DESIGN & CONSERVATION OFFICER'S REPORT:

Site Address: 3 QUEENS ROAD, BRIDPORT, DT6 5AW

Application Reference: WD/D/20/002982

Application Proposal: Erection of two storey rear extension and front porch

**20/057/04** Rev

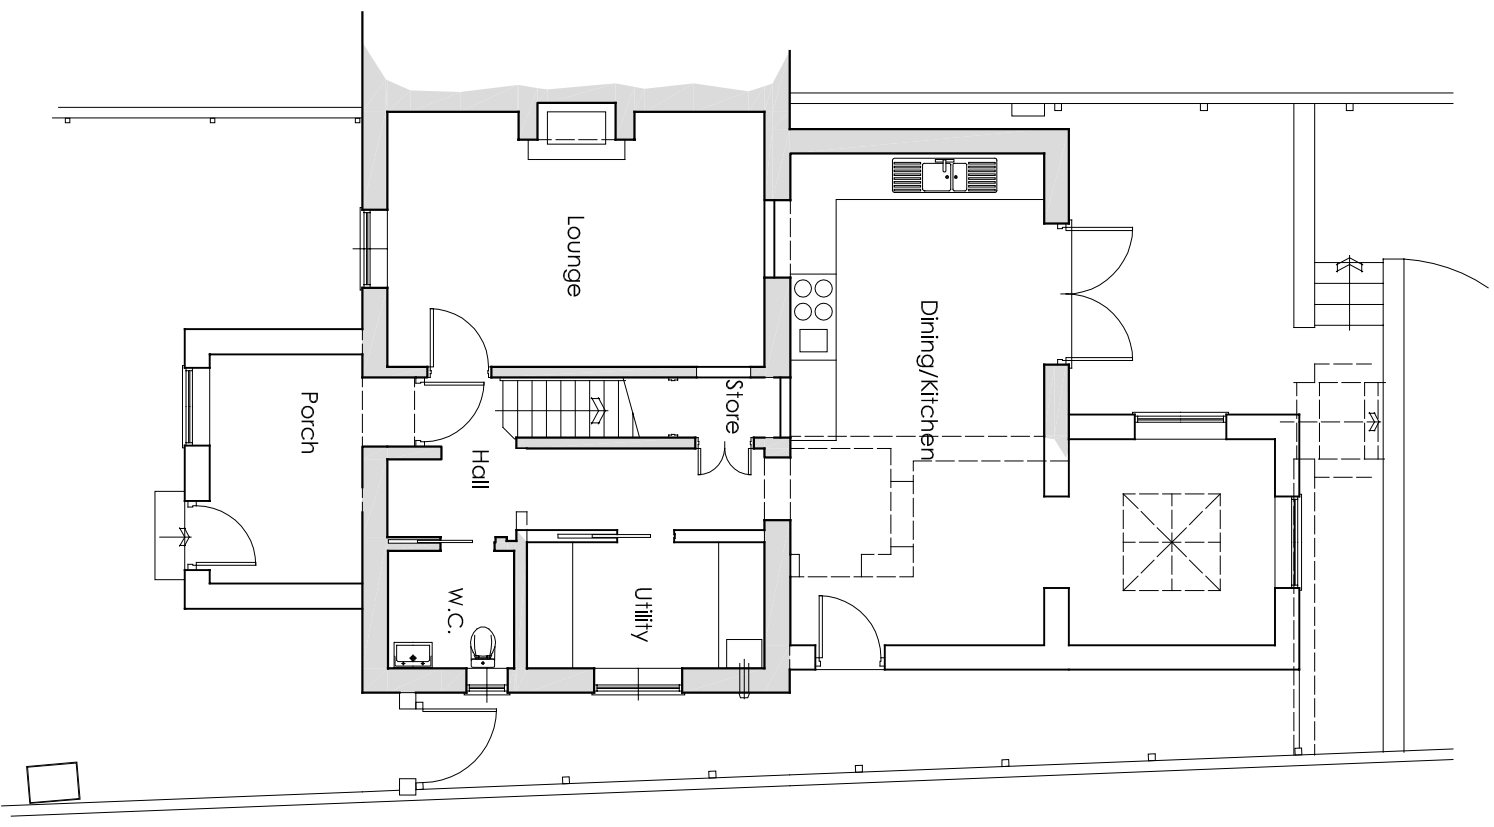
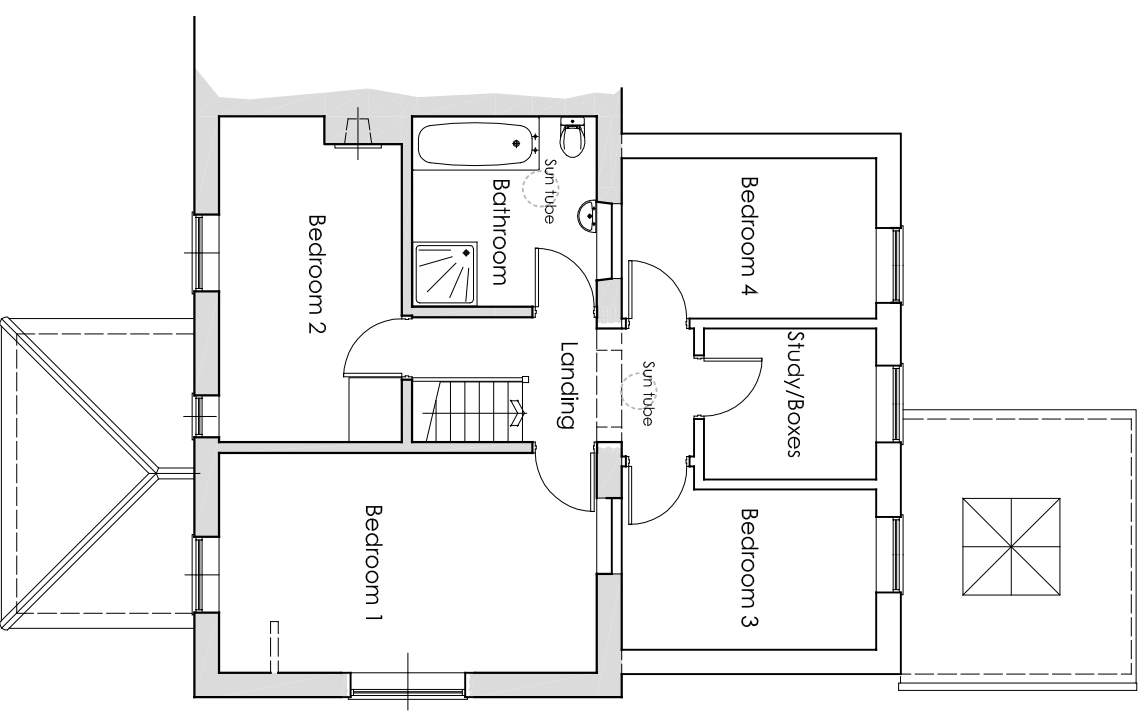
At the rear of the property, there is an existing single-storey extension providing the current Dining Room and Utility Room. These are simple structures and clearly later additions and we have no objections in principle to their removal and replacement. Looking at aerial

imagery, large-scale rear extensions are present in the locality, but are rarer than simple, single-storey extensions which go further in retaining the original scale and character of the houses which, again, are remarkably uniform in these respects. The scale and character of No. 3 is particularly appreciable as it is set forward from the line of Nos. 5-7, meaning that its W gable (and rear extension) are visible from Queens Road. It is considered that a two-storey extension here would out-of-character and visually prominent, and thus detrimental to the character of the Conservation Area.

- removal of proposed porch element, or some other innovative solution which lessened its scale and retained a rounded brick arch brick detail; and
- reduction in scale of rear extension to single storey.

20/057/05 Rev

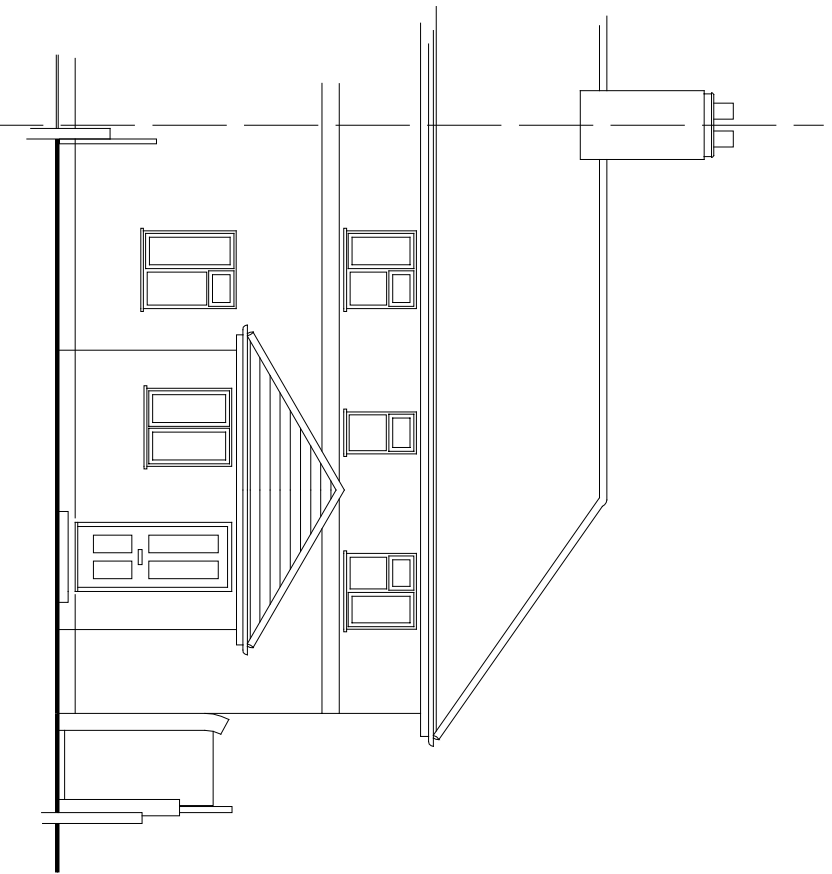
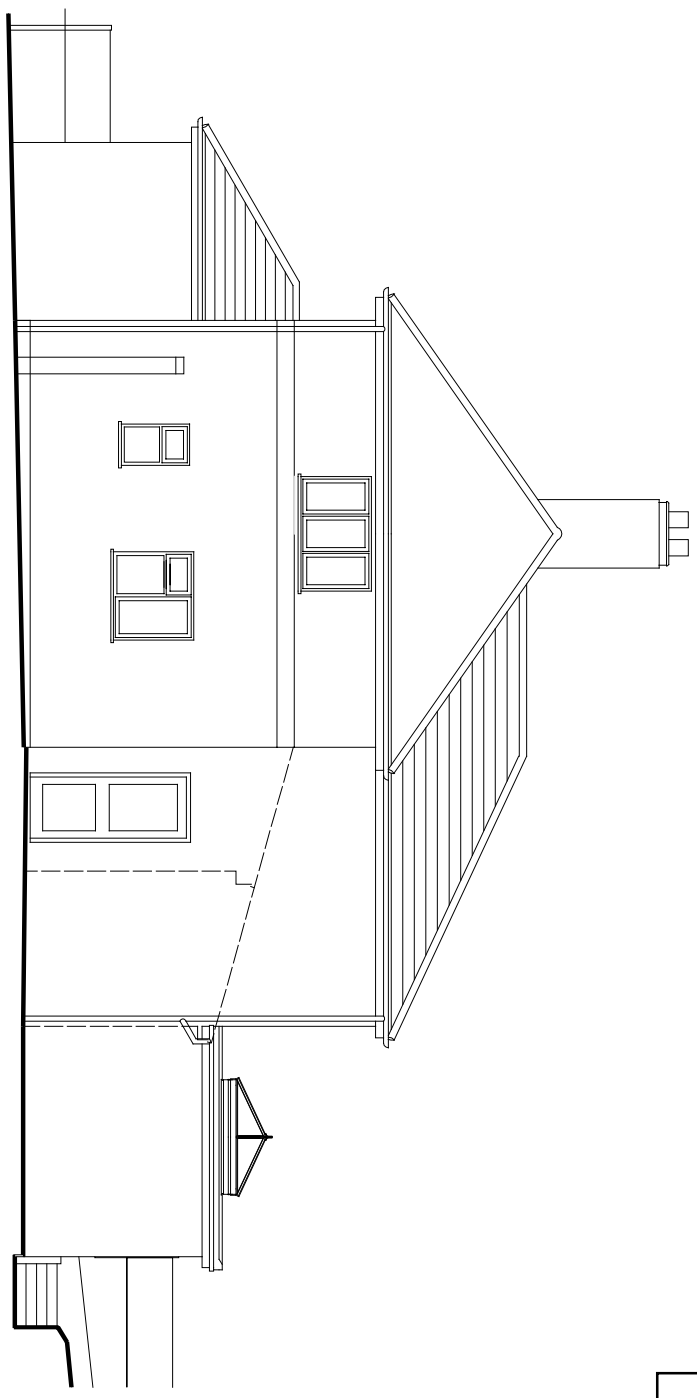
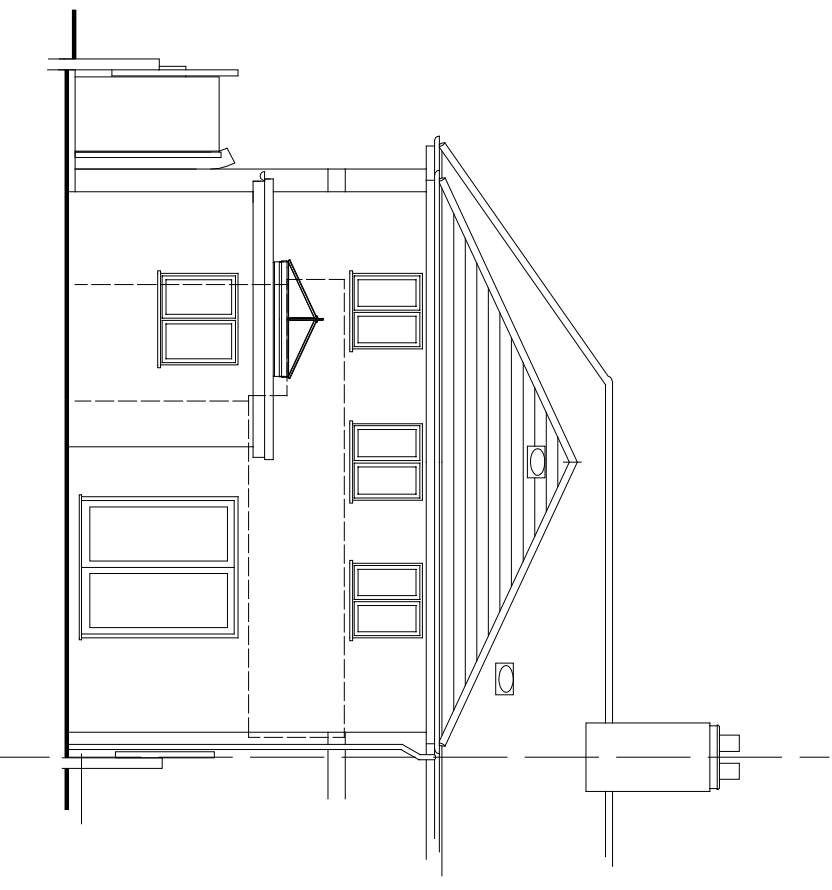
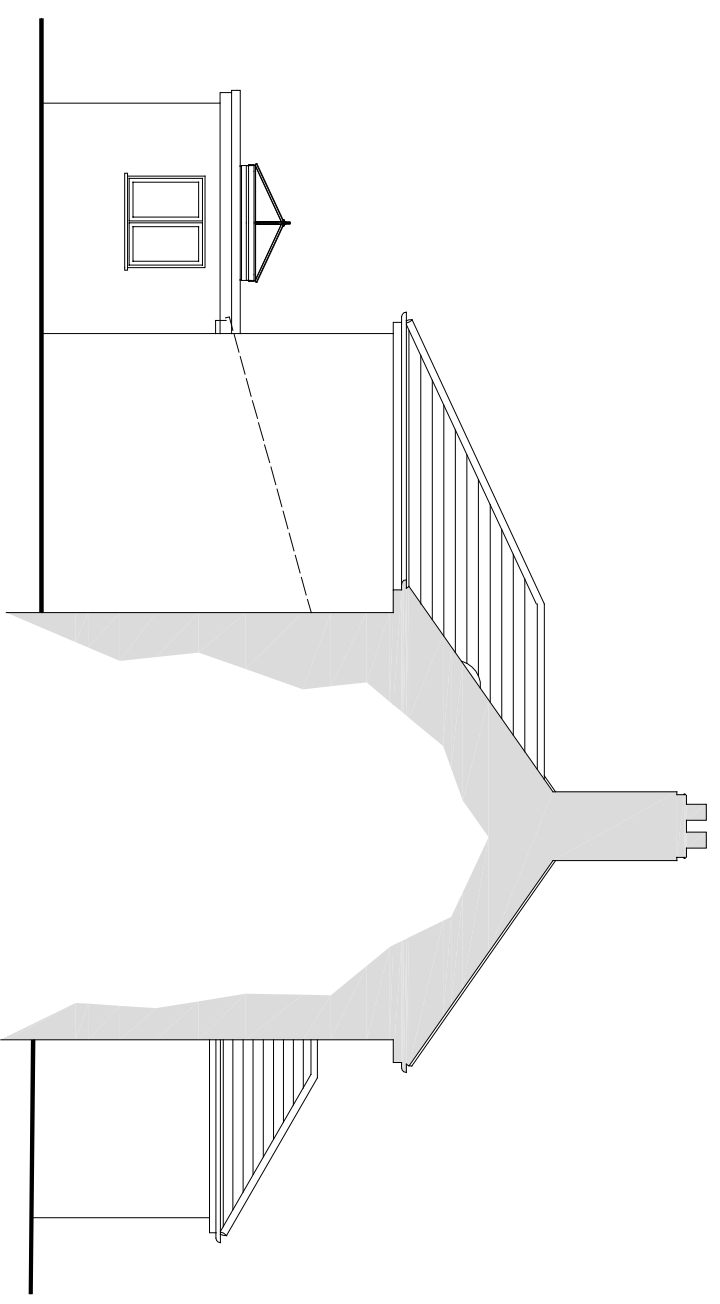
One of these characteristics is the extent to which the original appearance and form of the buildings around Queens Road survives with few significant changes. Porches/front extensions have been added to Nos. 10, 11 and 18 and to a handful of buildings along Alexandra Road, but overall the majority of the houses retain their original, simple frontages and these aforementioned additions detract from the area's character and appearance. Added to the semi-detached pair of Nos. 1 and 3 are situated at a prominent position at the junction of Queens Road and Alexandra Road, with their frontages prominent from Alexandra Road to the N. Though the proposed porch is modest in size, it will considerably alter the front elevation, not least by obscuring the current inset porch with the distinctive rounded brick arch that characterises the houses on the S side of Queens Road and, indeed, distinguishes them from surrounding houses with their flat-head doorways. For these reasons we do not feel able to support the introduction of a porch.

On the above basis, we consider that the proposals would result in harm to the character and appearance of the Conservation Area through eroding the characteristic uniformity of scale and design of the existing development. However, we consider that our concerns could be fully or partly addressed through one or more of the following means:
